Re: Tasty Taco MFU #EHFL2303-001

The Tasty Taco mobile food unit was evaluated on March 29th at the location of the proposed commissary, Ay Wey Mexican. A permit was not issued for the mobile food unit and the evaluation of the commissary found critical issues which must be addressed.

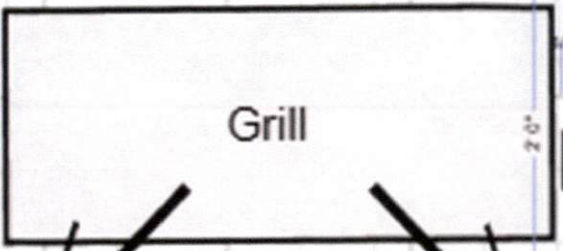
1. The waste tank was leaking in multiple areas and tape was present along the tank seams.
2. Old caulk was soiled and loose.
3. Pipes leaking under sinks.

4. Holes to the exterior were present in mobile food unit walls.
5. Remove unapproved shelf above handsink.
6. Rusty brackets securing equipment were present in multiple areas.

7. Rusty shelving.
8. Provide additional shelving racks in condiment cooler.
9. Wastewater disposal emptying on the ground. Wastewater tank outlet not approved and no way to properly remove grey water through a hose and in to a can wash.

10. Food grade hose is required to get potable water in to the clean water tank.
11. Provide an approved location for getting potable water. Discussed an exterior faucet, dedicated only for mobile food unit potable water source and faucet must be protected. If an alternative to the exterior faucet is desired, provide the details for review.
